East Park Energy

Applicant's Response to Deadline 4 and 5 Submissions – Other Interested Parties

Document Reference: EN010141/DR/8.70

August 2026

© Crown copyright and database rights 2025.
Ordnance Survey AC0000808122

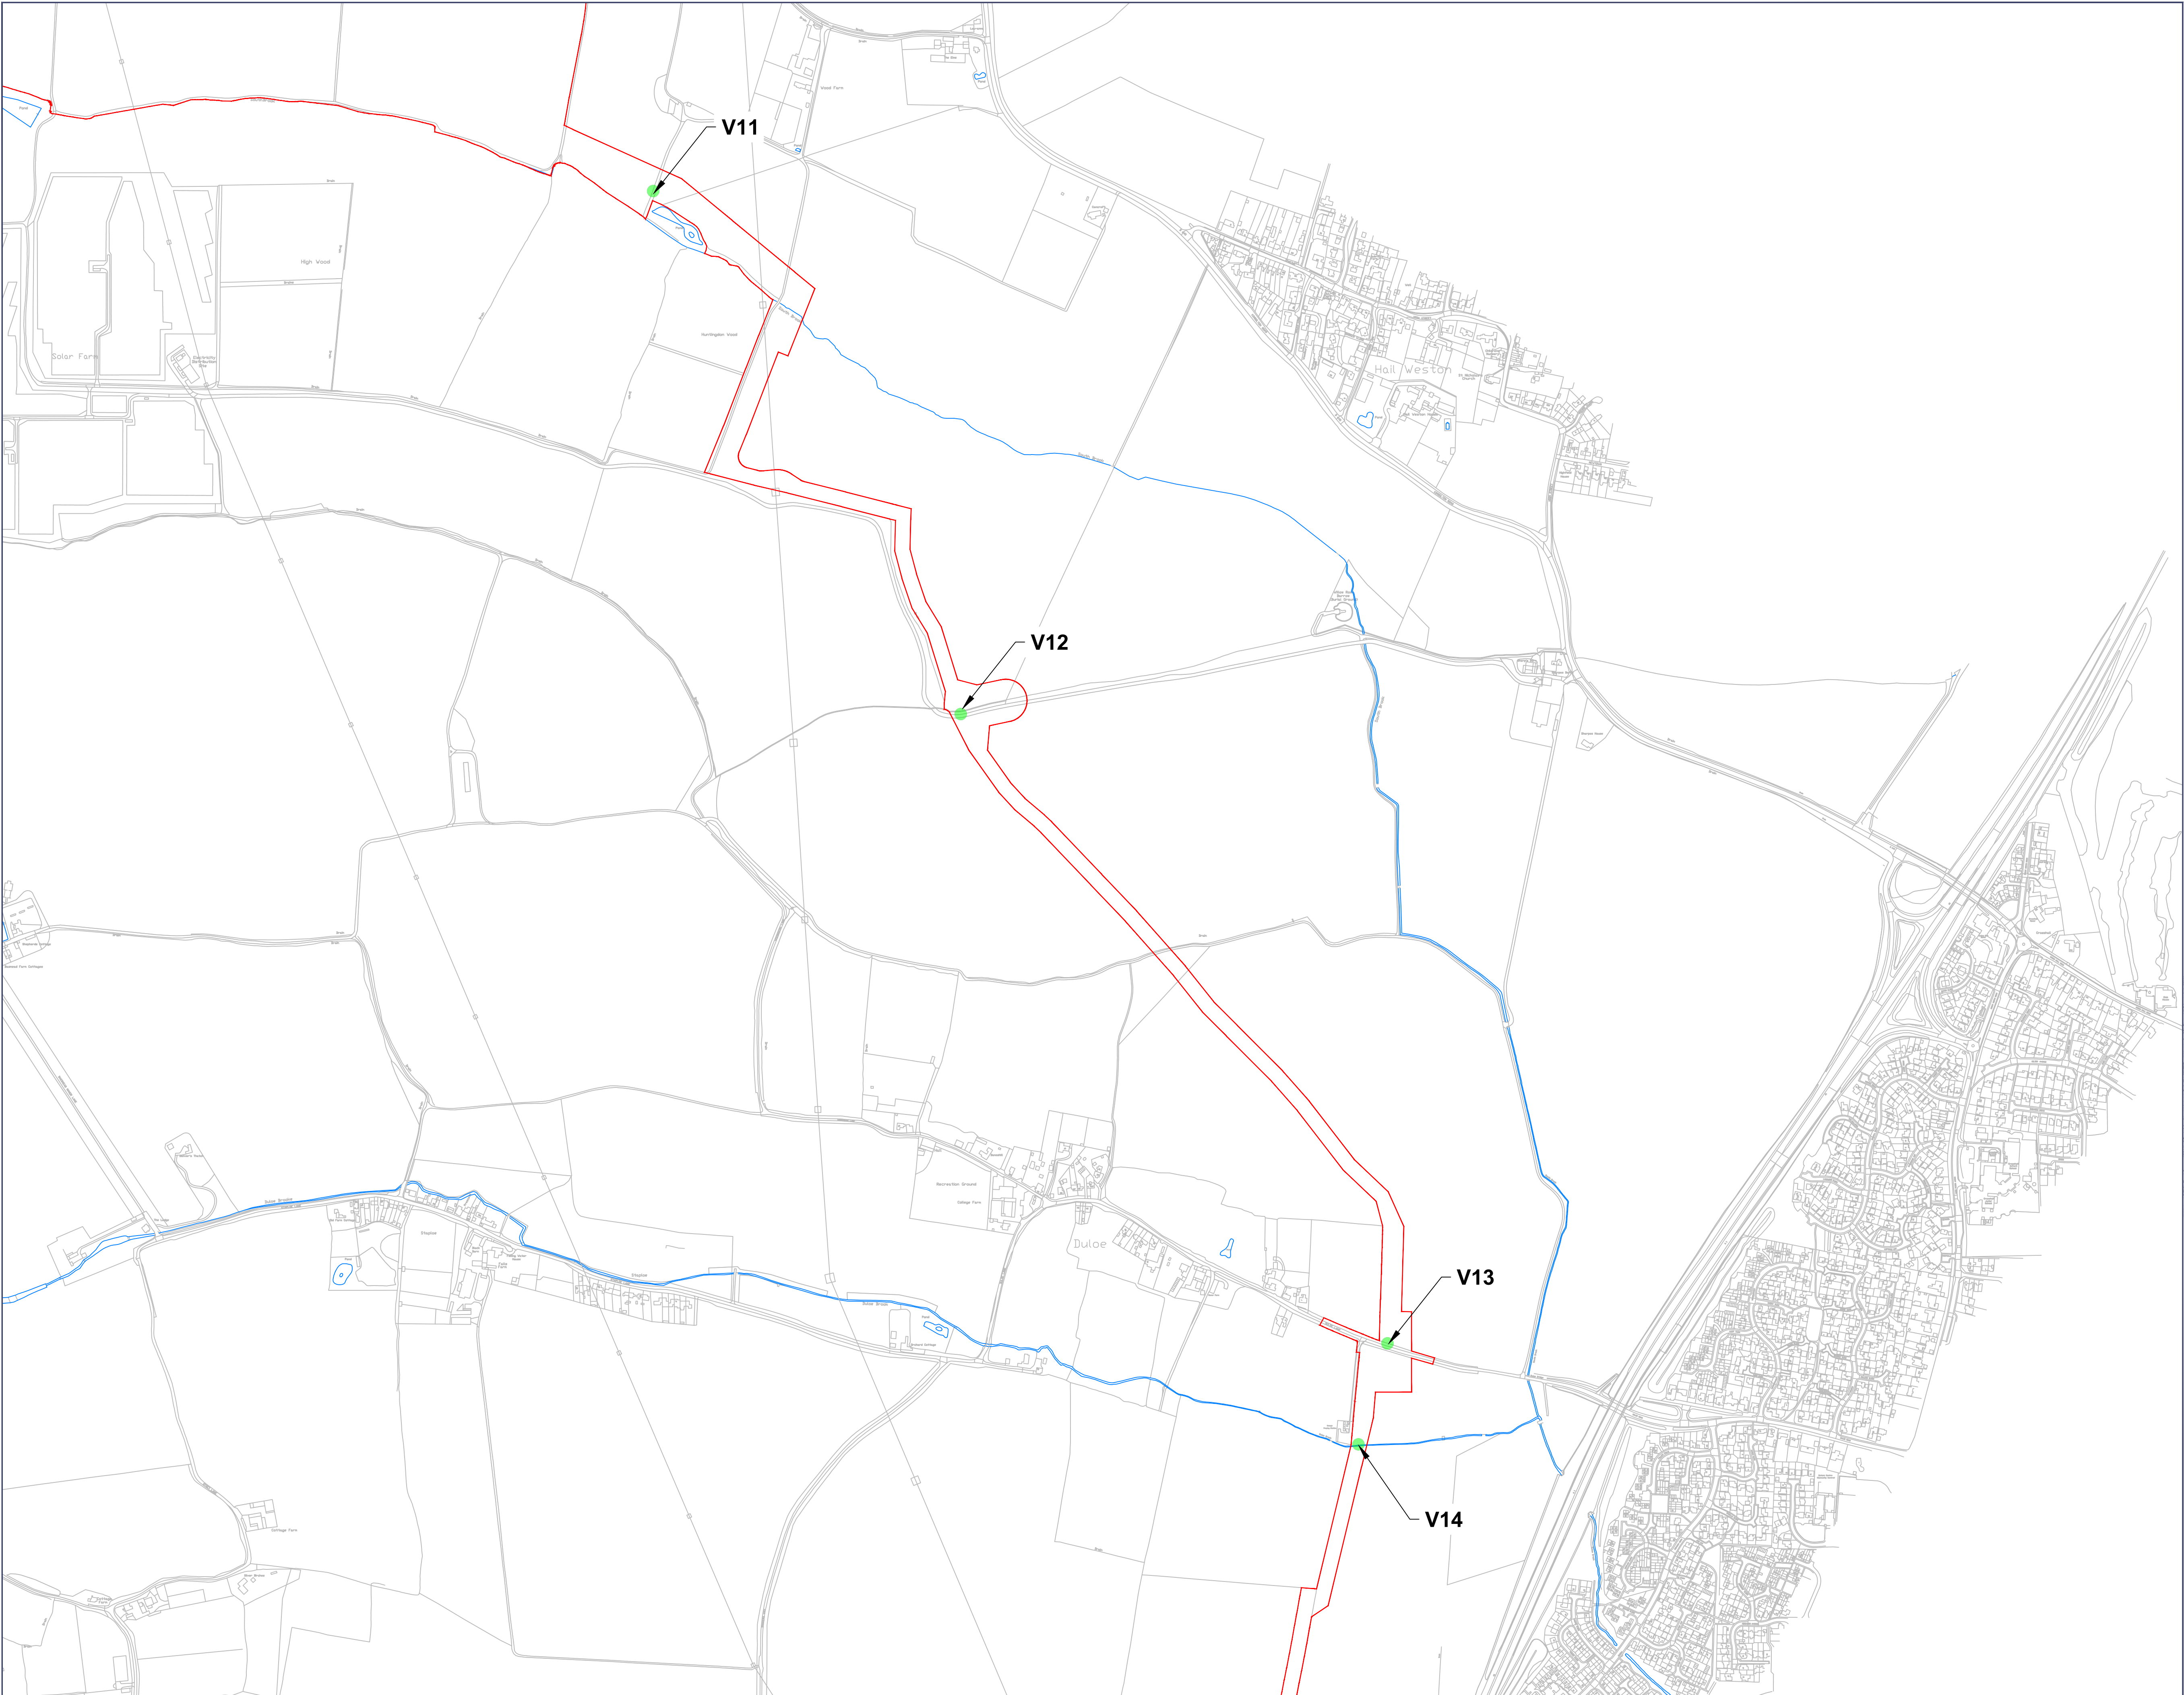
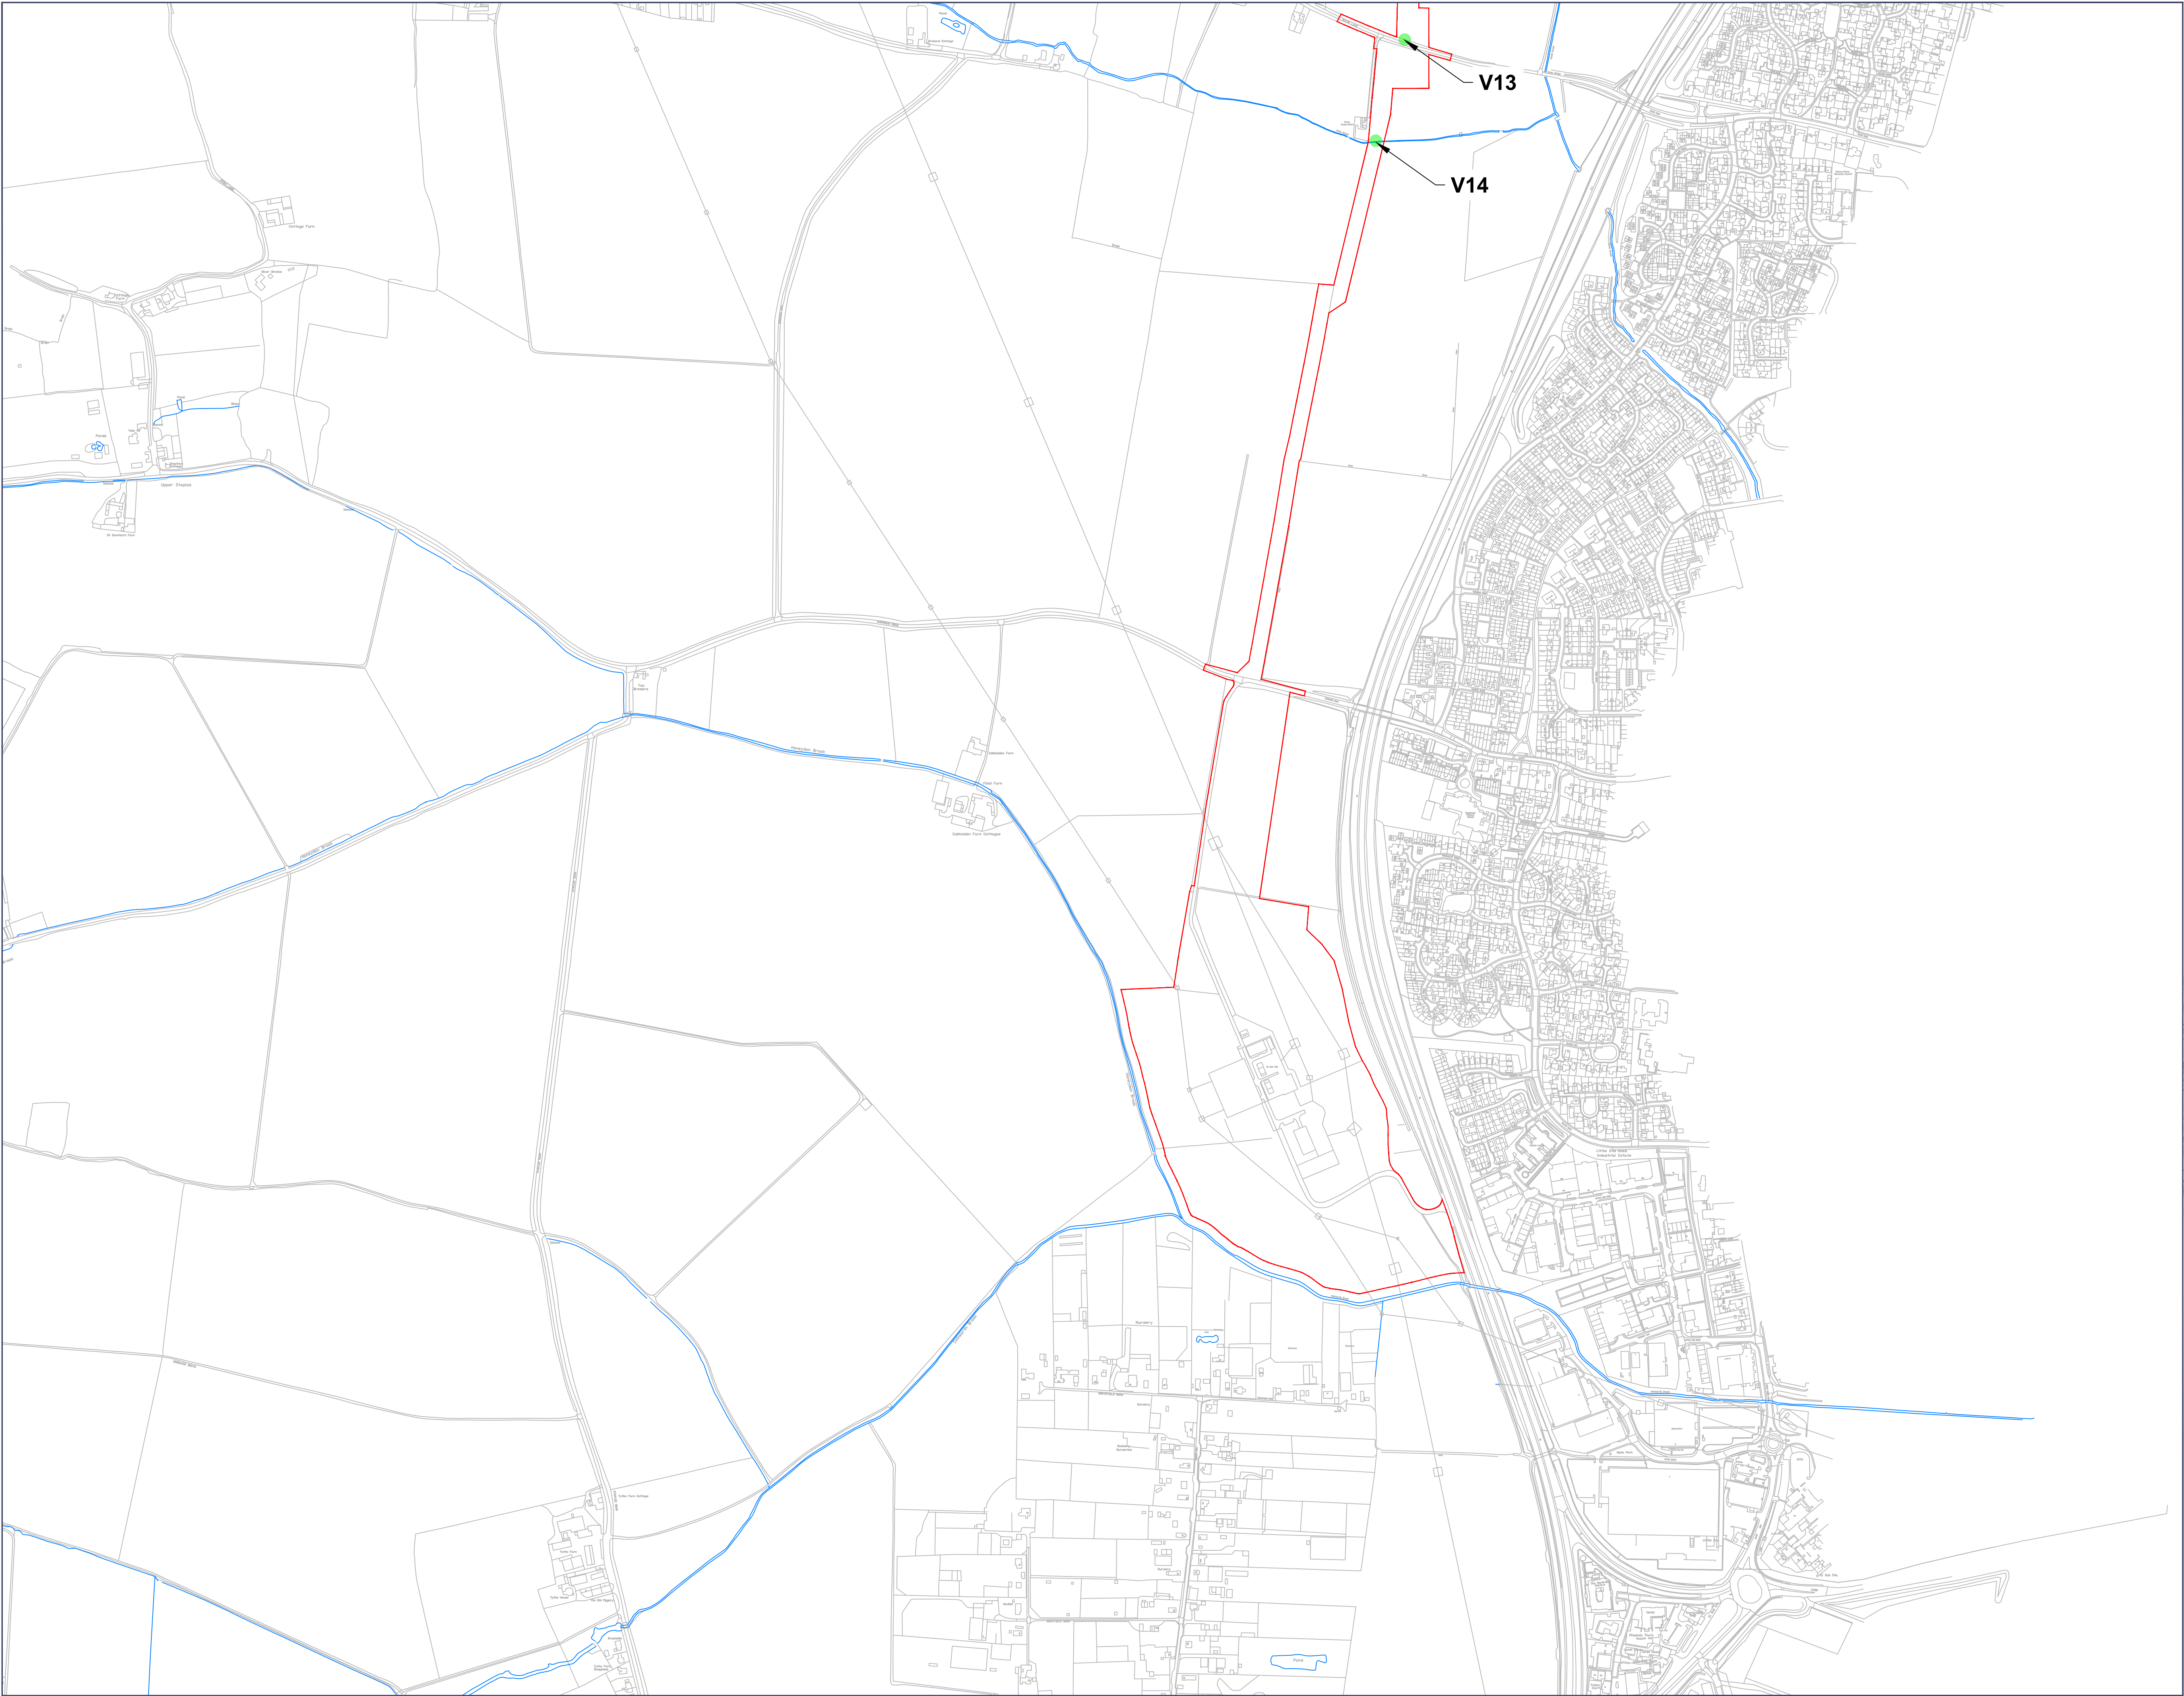
PM-D5-04	What damage will be done when putting all the access points in to get this construction completed, how big will the access points be and what level of hedge. Tree screening will be damaged for all site access points, also what limitation on signs that are likely to be there for 3 years will be put in place?	The oCTMP [REP4-095] includes a series of drawings, in Appendix D, showing the site access drawings. The required vegetation clearance is best shown on ES Vol 3 Figure 2-6 Indicative Vegetation Clearance [APP-126], supported by the description in Table 2-34 of ES Vol 1 Chapter 2

Our Ref.	Comment	Applicant Response
PM-D5-05	What level of hedge and tree removal is planned to achieve this development, where is the overall assessment of the impact to wildlife/villagers and visual appearance been made. What will happen to gaps within hedgerow is there are planting statement if removal is needed or damaged, rather than a sea of panels as far as the eye can see ? A timebound plan that happens at set points during construction not at the end of the project when it could get overlooked	[APP-038]. A Tree Impacts Plan is also provided as part of ES Vol 2 Appendix 2-2 Arboricultural Impact Assessment [APP-056]. Mitigation measures to control impacts such as signage at access points are set out in the oCTMP [REP4-095].
